Ribble Valley Borough Council
Housing & Development Control

Your ref 3/2022/0727
Our ref D3.2022.0727
Date 31st August 2022

Application no: **3/2022/0727**

Address: **Lower Reaps Farm Whinney Lane Mellor BB2 7EL**

Scale: 1:2500 | Area 36Ha | Grid Reference: 366348,430280 | Paper Size: A3

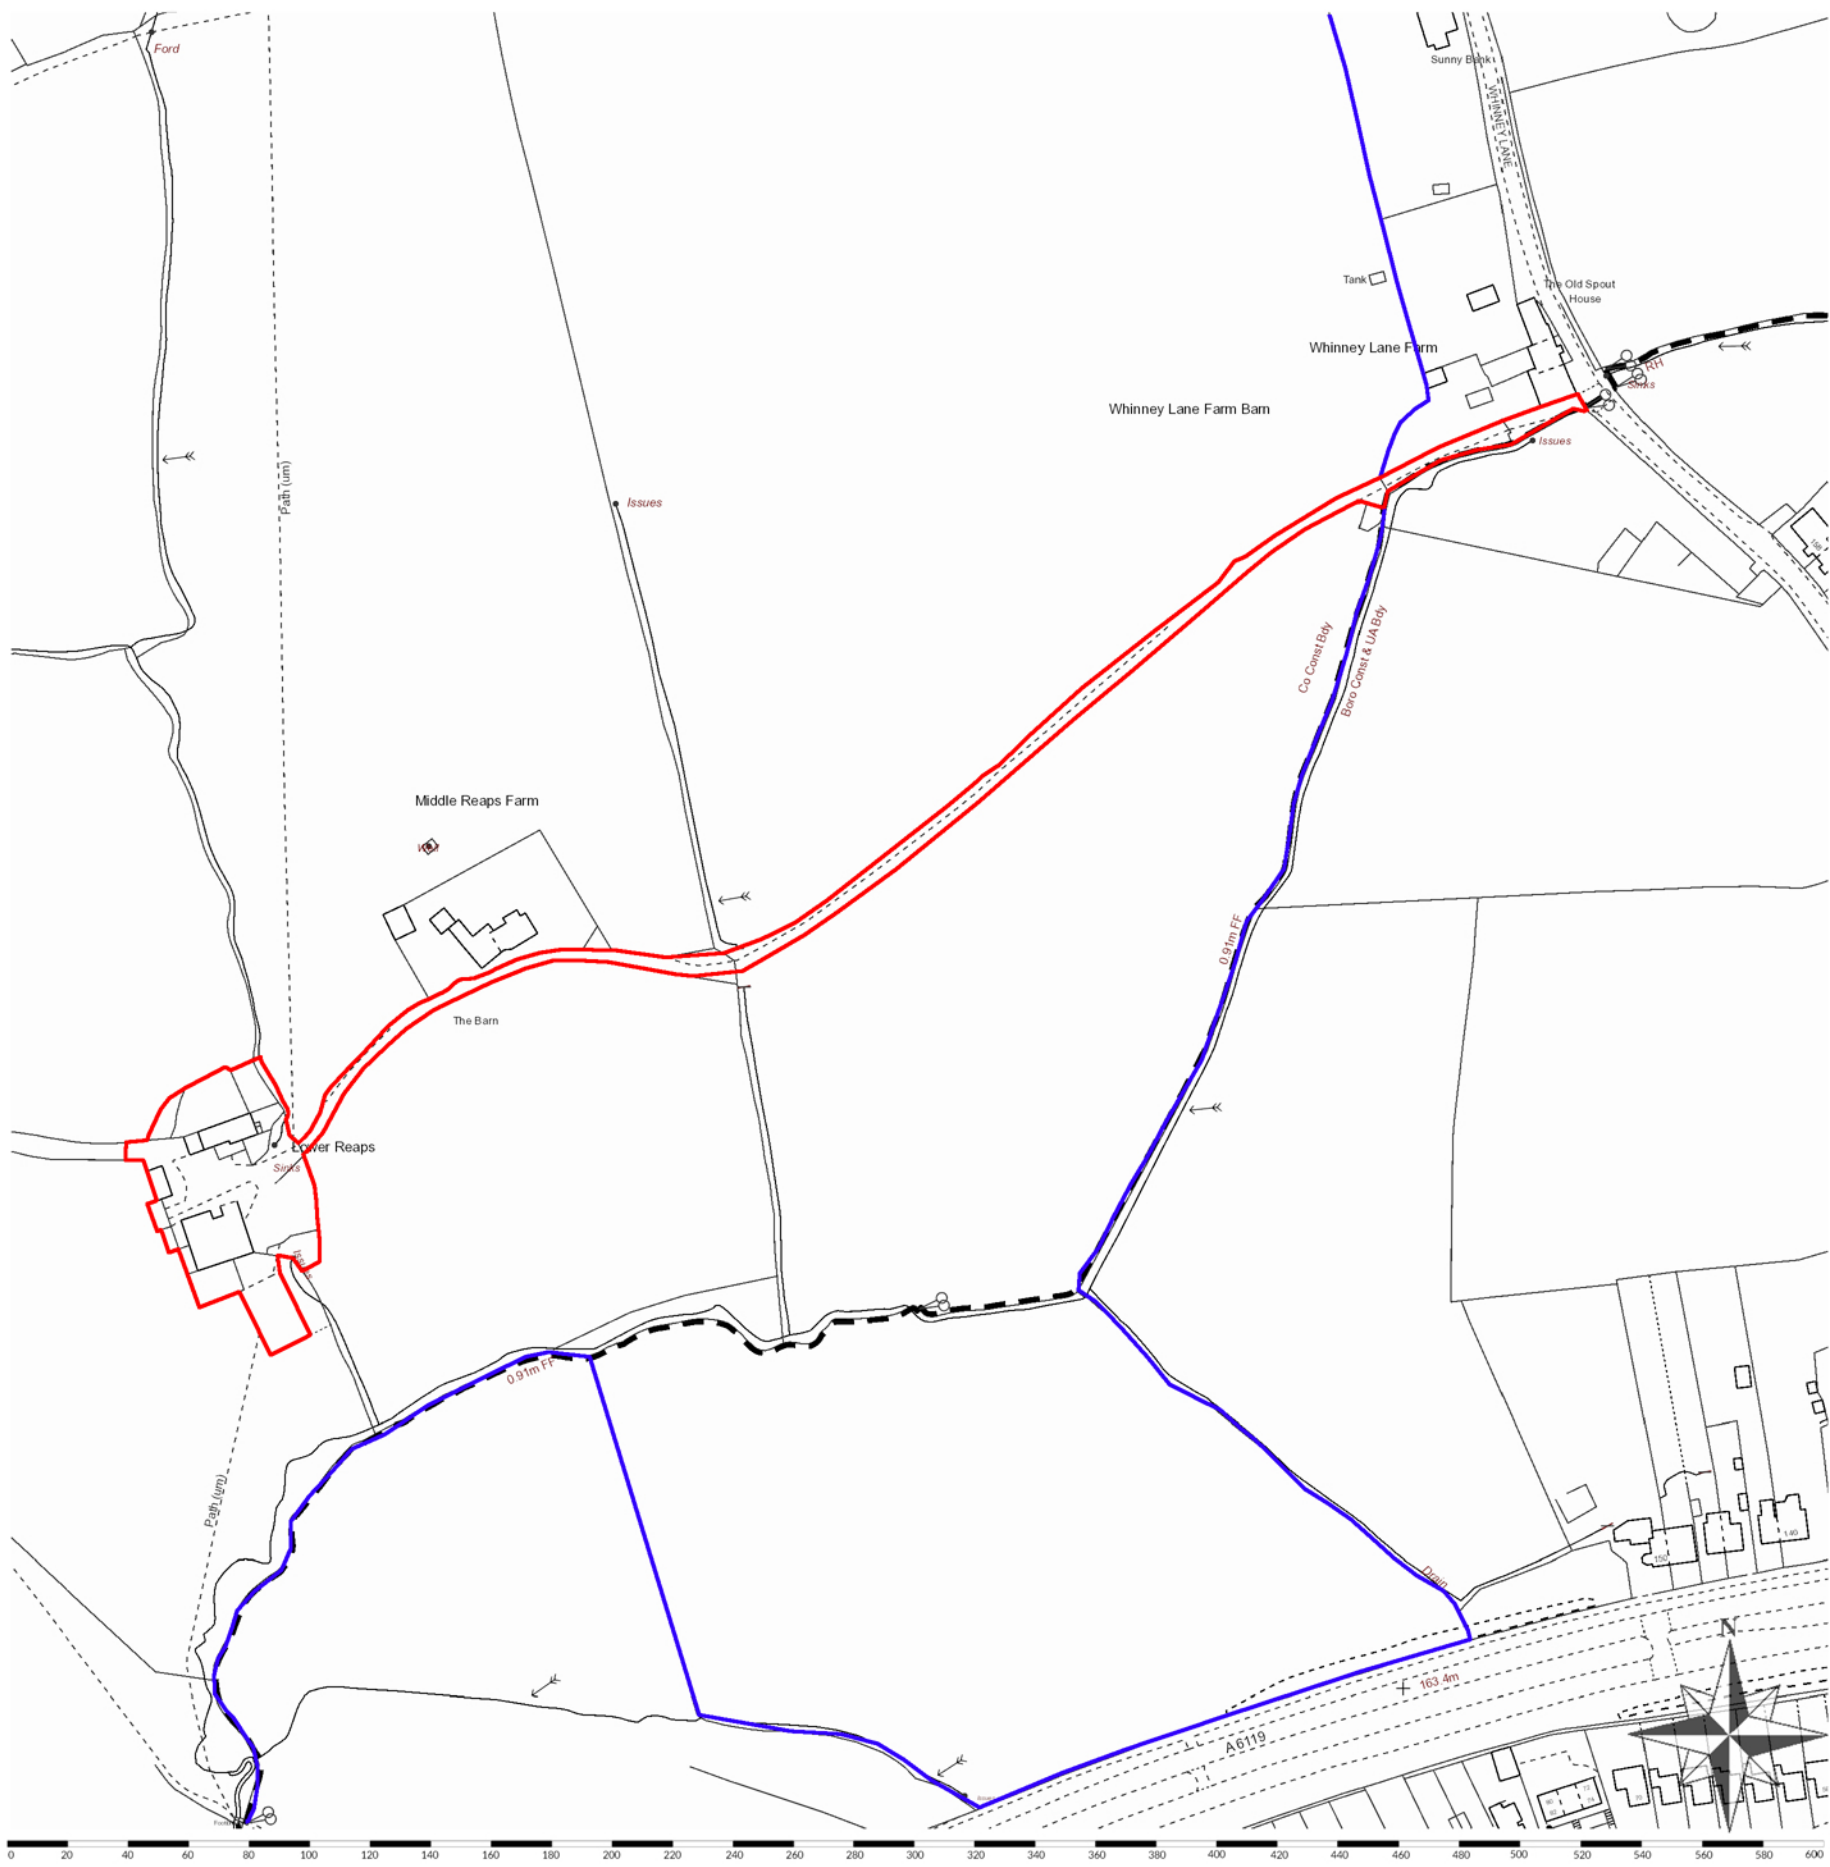
The LHA have reviewed the drawing provided by Groundsure titled "Location Plan" which shows the access located off Whinney Lane and the existing access track into the site are aware that the access width complies with the LHAs guidance.

However, following the intensification of use of the access following the proposal, the LHA require a visibility splay drawing to be provided. The LHA require visibility splays of 2.4m x 43m to be provided in both directions. Should the access not be able to achieve this, a speed survey is required demonstrating the 85th percentile speeds within the vicinity of the site.

The LHA have also reviewed the access track and due to the single-track nature, the LHA require passing places to be provided a minimum of every 200m to ensure two-way movements can occur along the track. The passing places should be 2.5m x 15m in length should Middle Reaps Farm still undertake agricultural practices at their site or 2.5m x 5.5m should Middle Reaps Farm have already ceased their agricultural use.

Should Middle Reaps Farm still undertake an agricultural use at their site, the length of the passing places which is a minimum of 15m, is important to ensure that large agricultural vehicles can wait in the passing places provided to ensure two-way movements can occur following the intensification of use of the track. These passing places should be shown on a revised drawing.
